13-15 & 17 Oxford Street and 2 Verona Street, Paddington

Submissions Report

Drawing Title
BASEMENT 1 PLAN

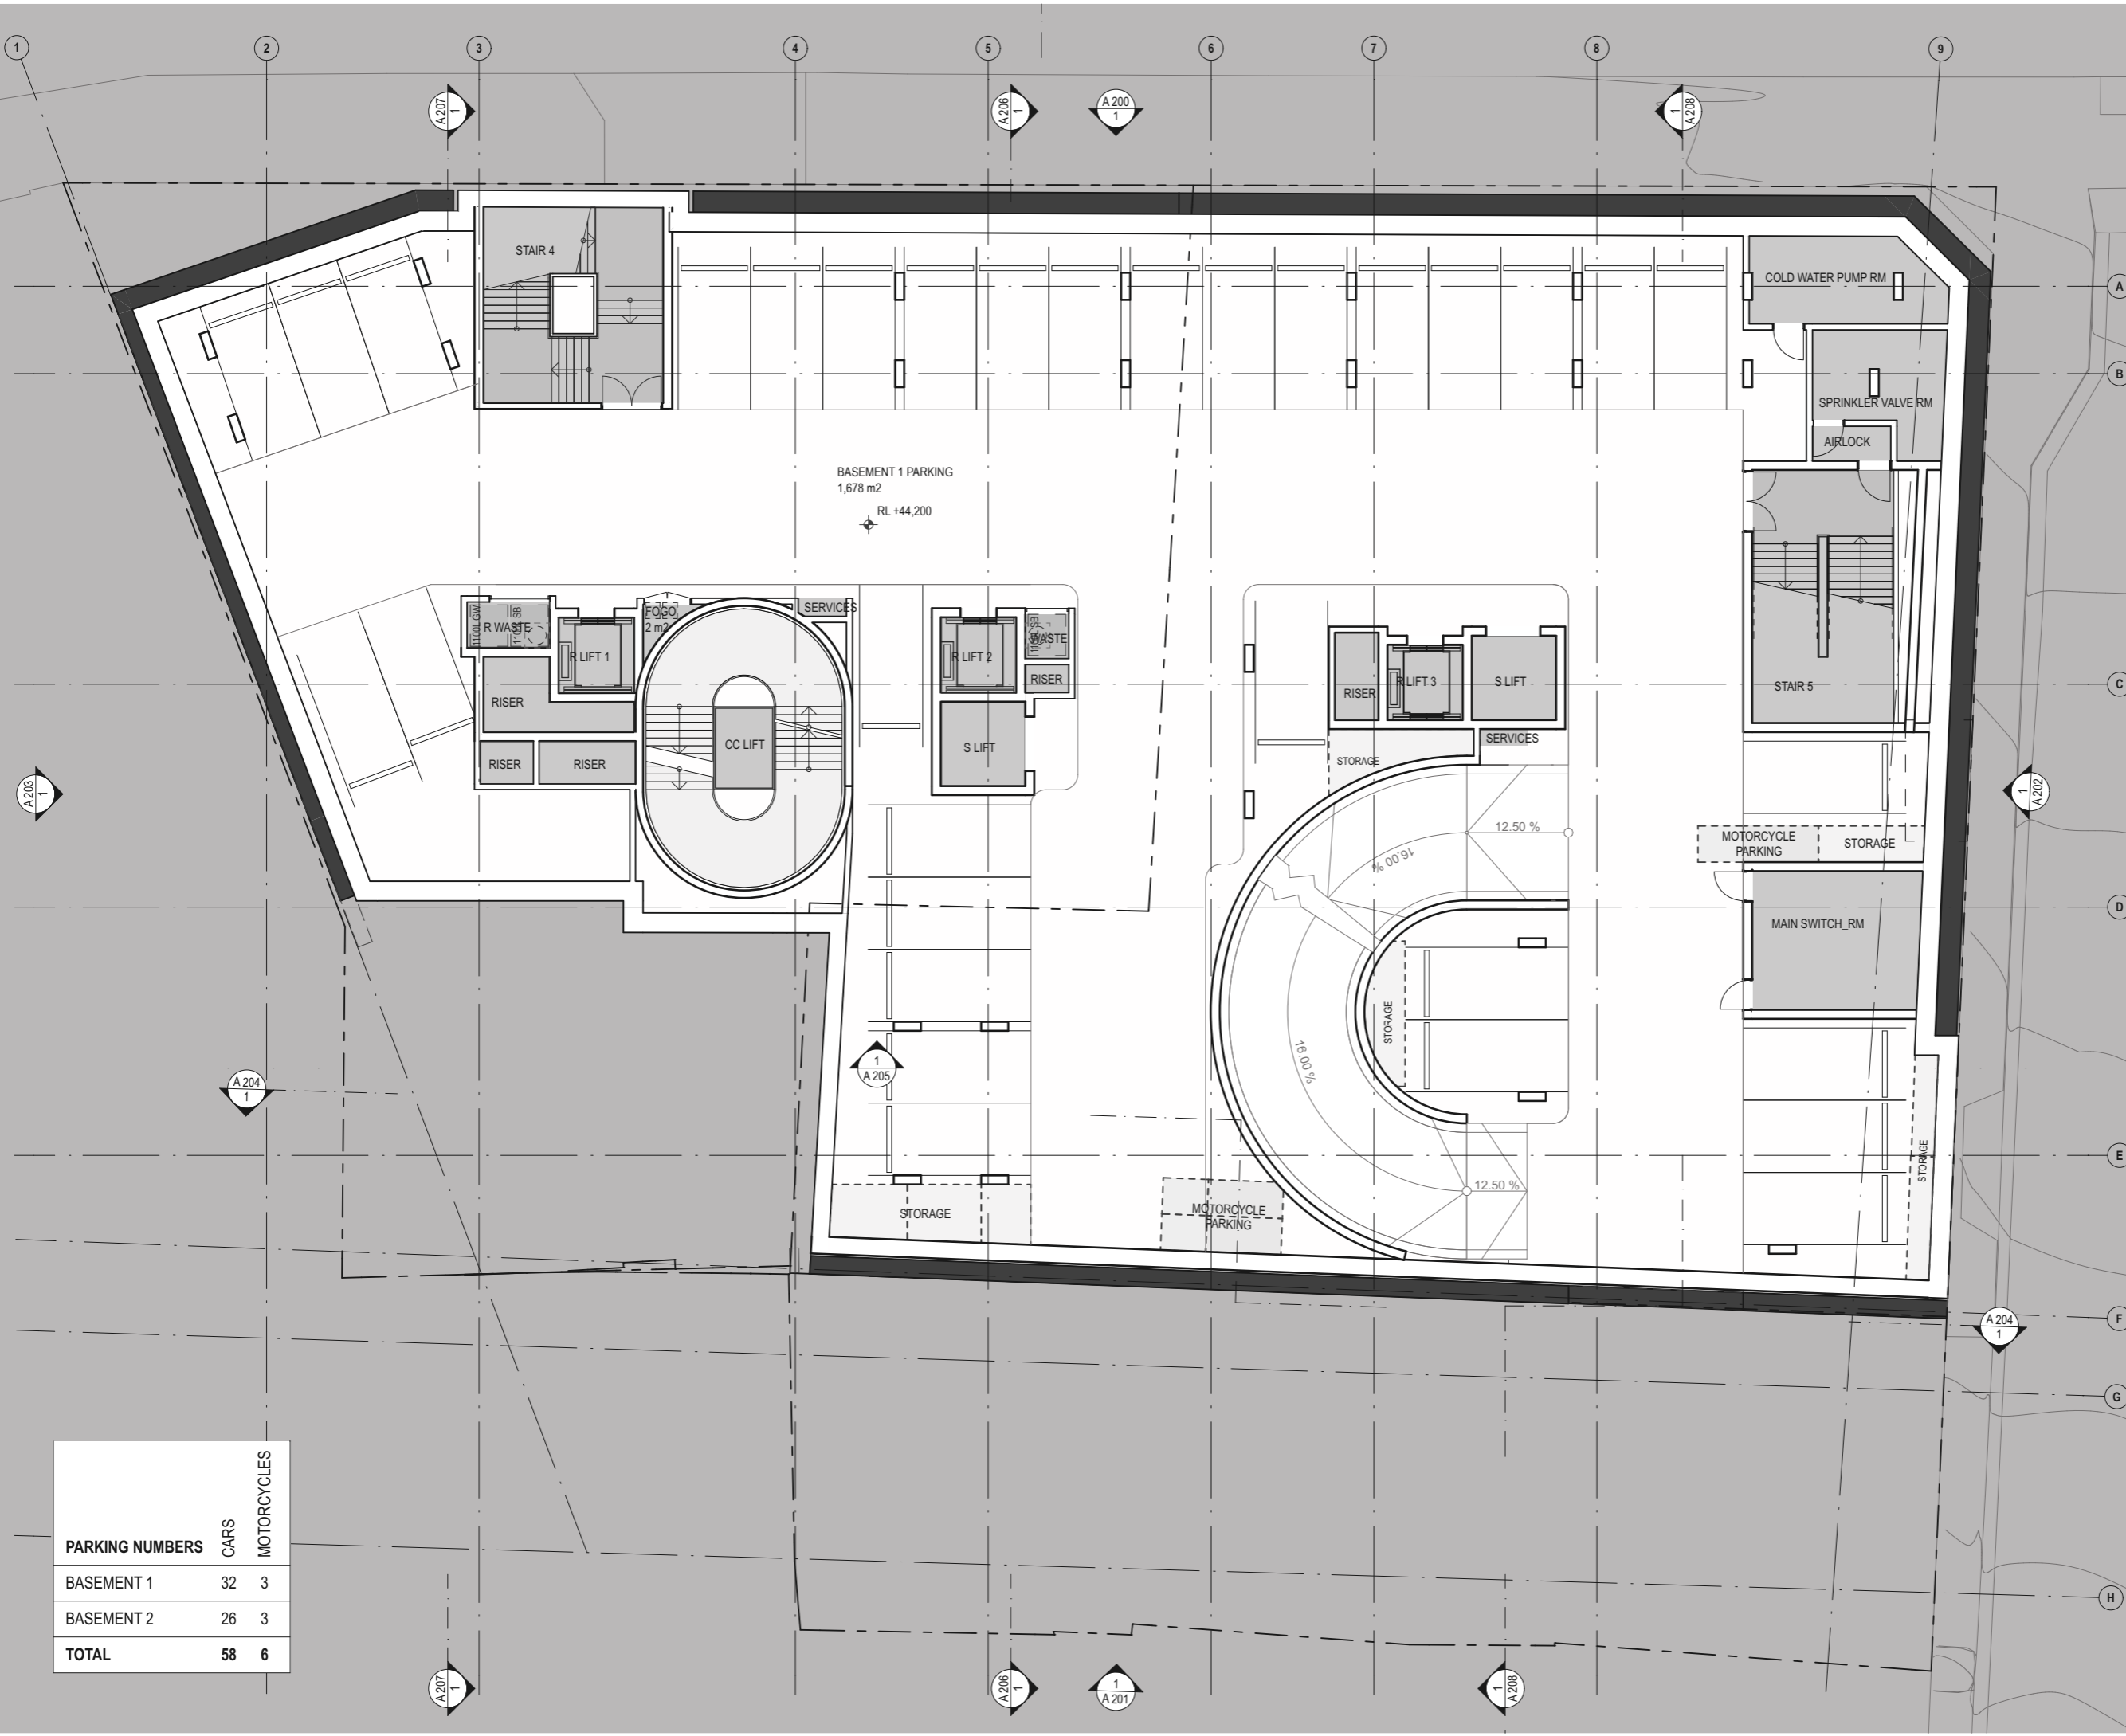
12. Update basement floorplans to label which storage areas belong to each apartment, including measurements (m3)	Updated basement plans have been provided as part of the refined submission, labelling each storage unit by apartment number and including the volume of each storage cage in cubic metres, where that storage cage is required to make up a shortfall of required storage per ADG requirements.

1 HEIGHT PLANE - 3D VIEW 1

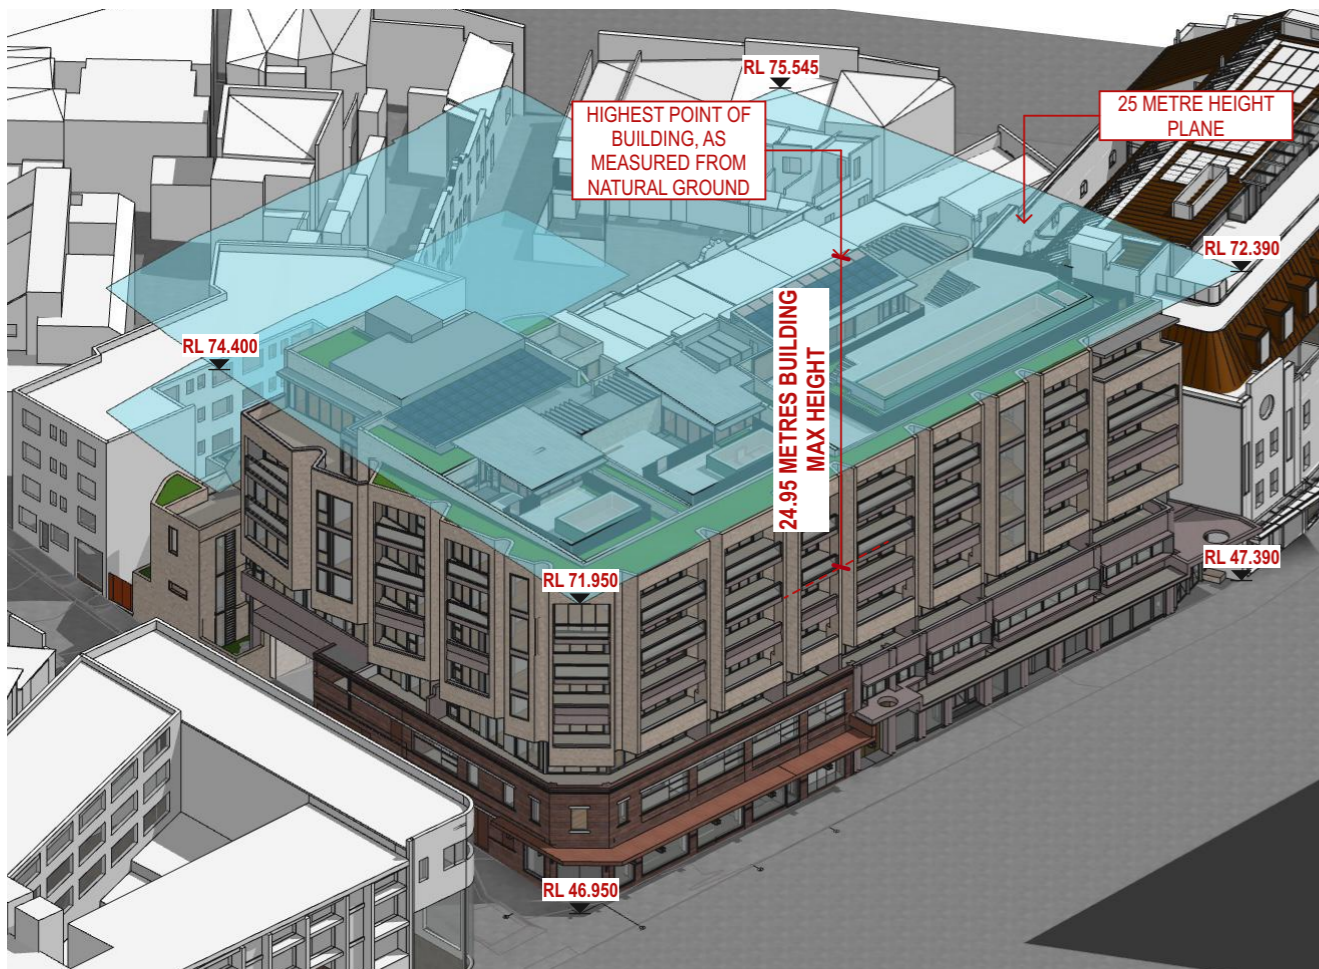
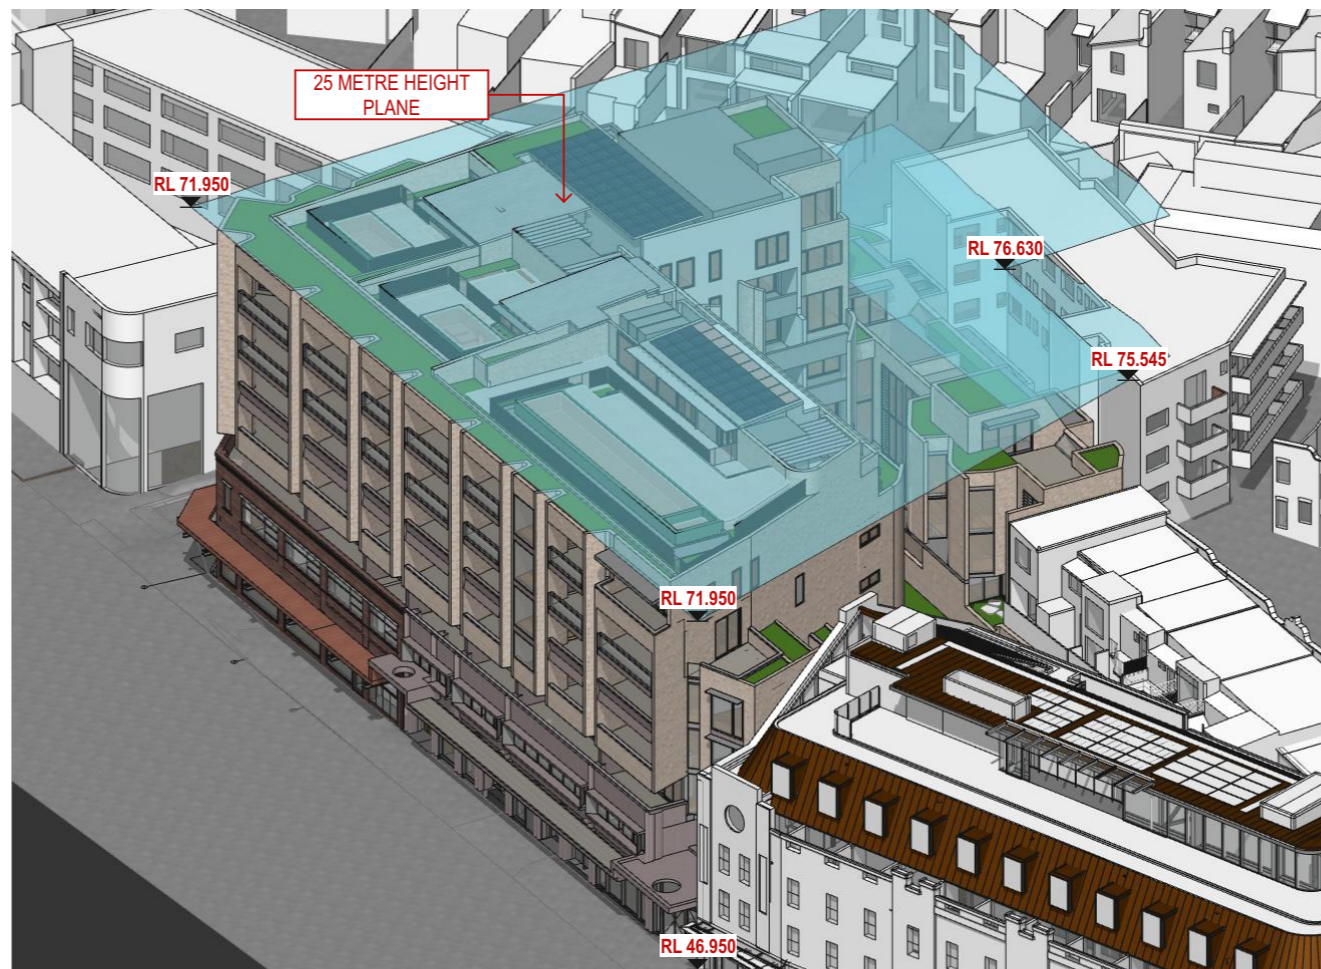
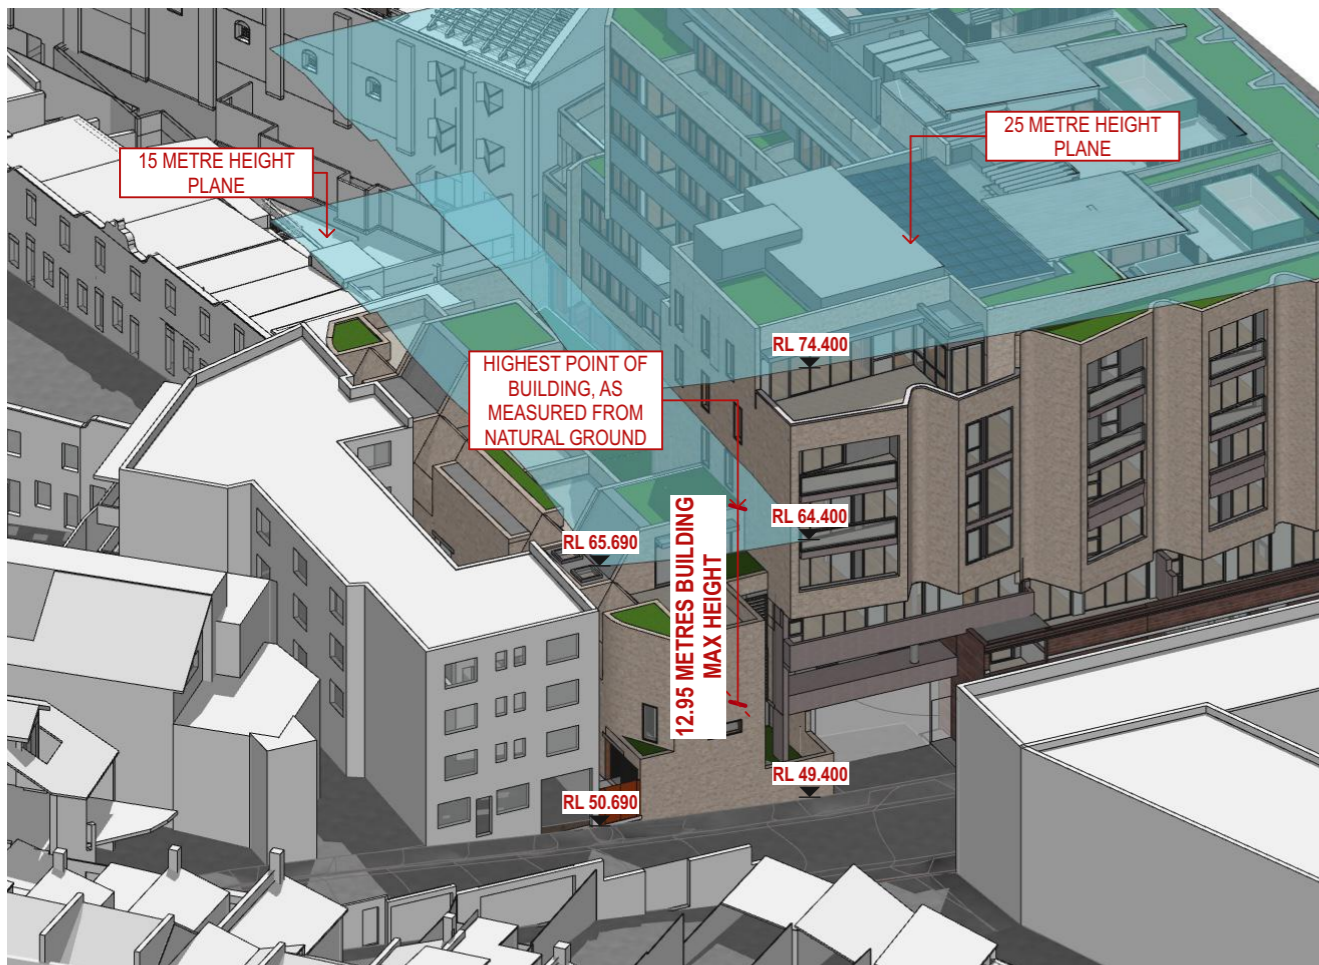
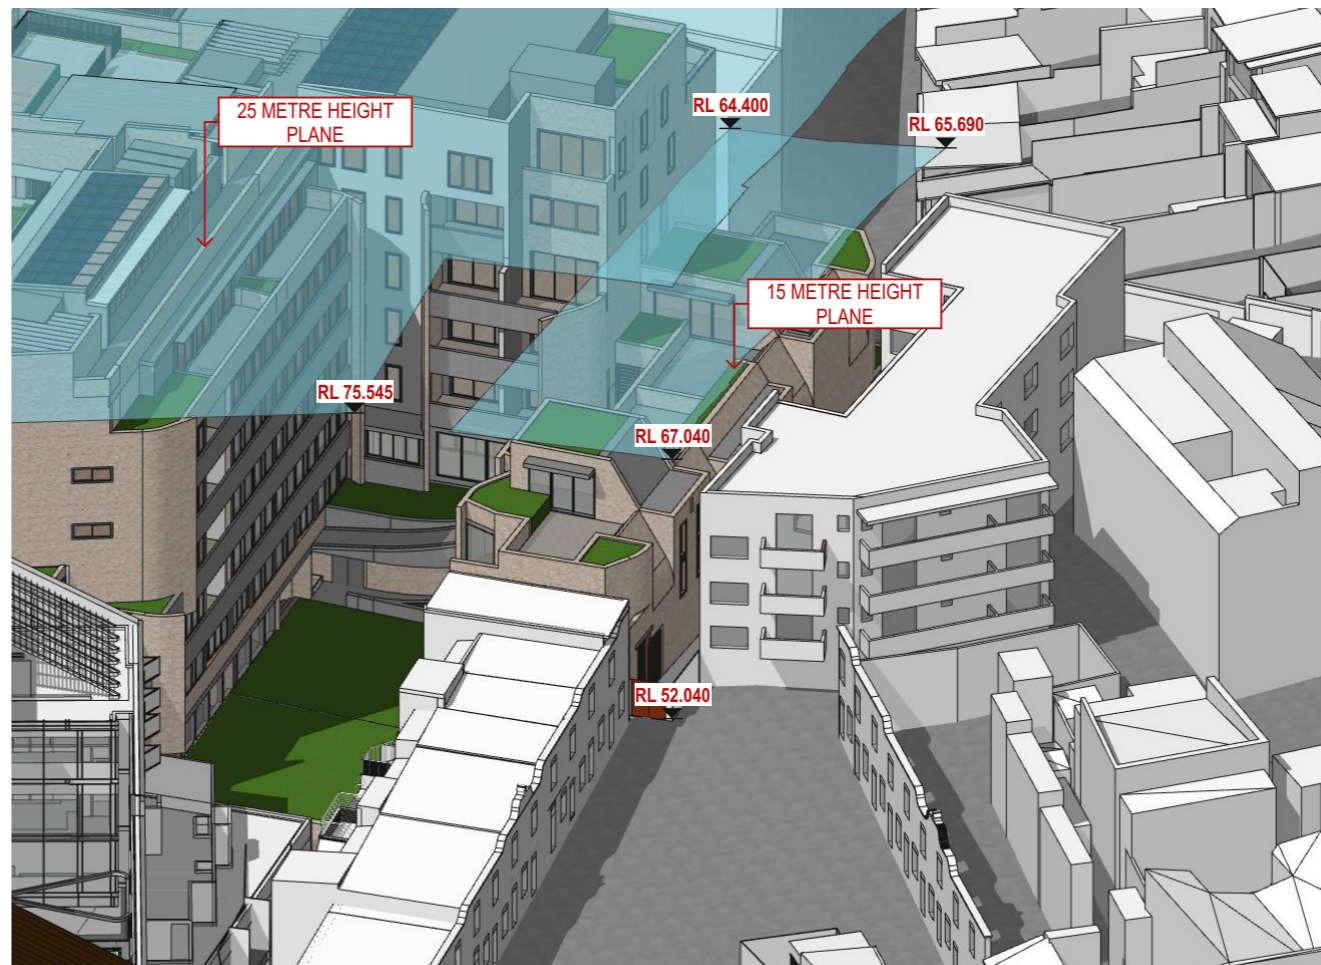
10. Provide additional sections drawings that clearly demonstrate the elevations of all roof level structures	Additional elevations of all rooftop structures not fully visible in the previously submitted elevation drawings have been provided as part of the refined submission.
